Thank you for your letter dated 20th May 2022. I am writing in reference to planning application 6/2022/1106/FULL having inspected the plans and other documentation available on the Welwyn Hatfield Borough Council website.

WEST ELEVATION

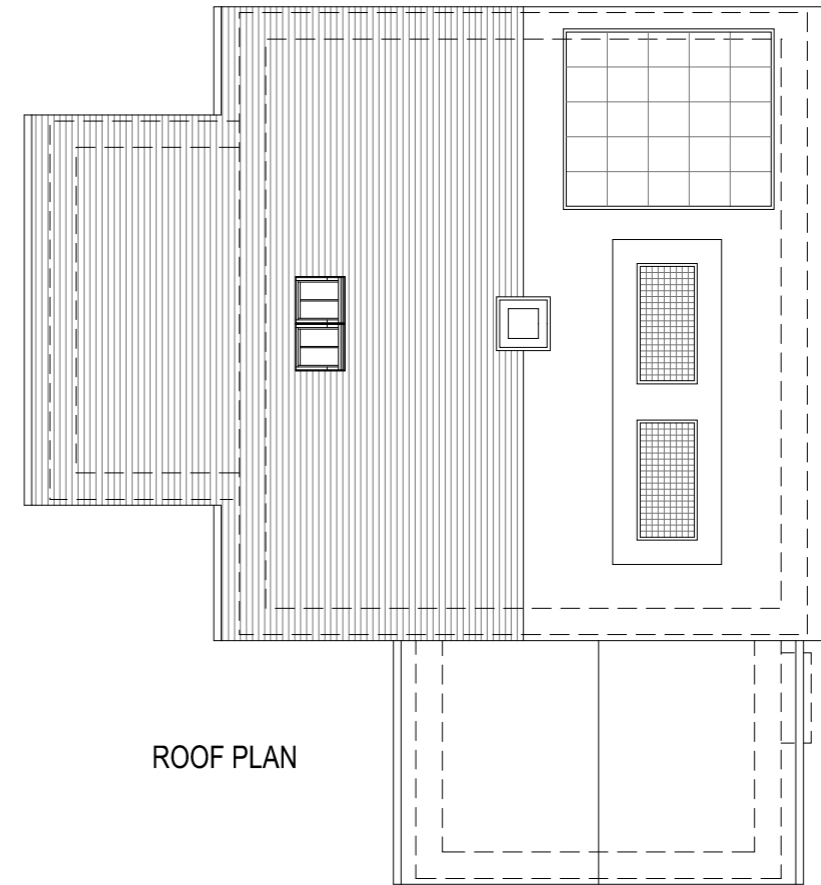
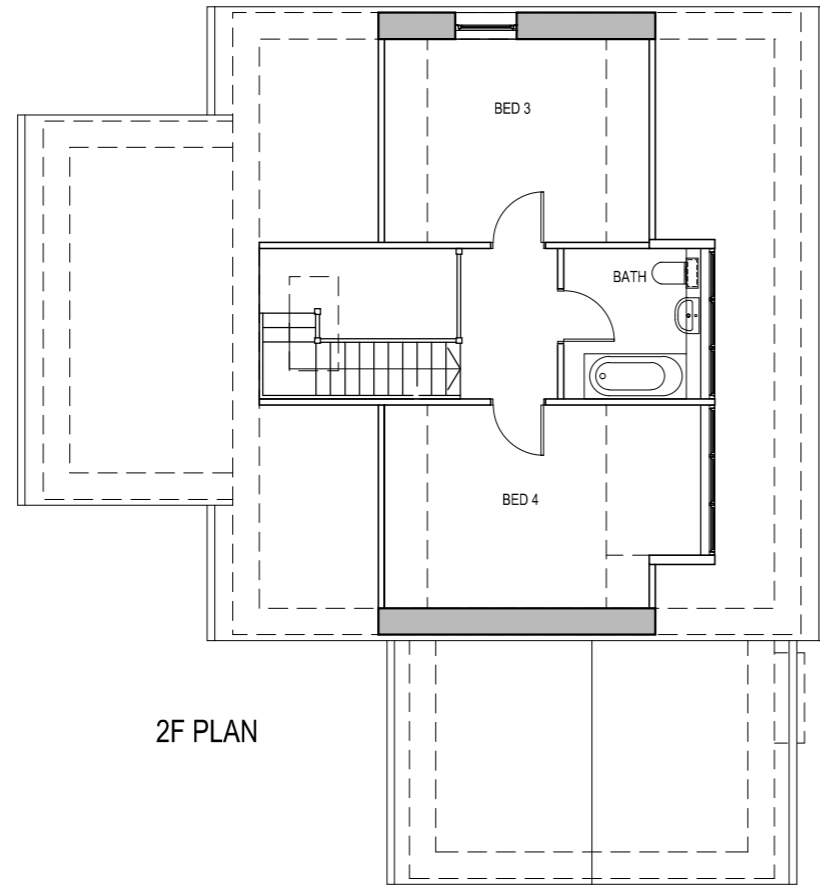
- i) Loss of amenity
The window on the west elevation of the proposed house behind 4 Longcroft Green would cause loss of privacy and potential loss of light to the rear second floor rooms. The numerous doors and windows on the south-east elevation of the proposed apartment block behind 3 Longcroft Green would directly overlook number 3 and cause loss of privacy and loss of light. In addition, the 'wrap-around' shape of the proposed development and substantial height of the apartment block would cause an overbearing sense of enclosure within the existing houses.
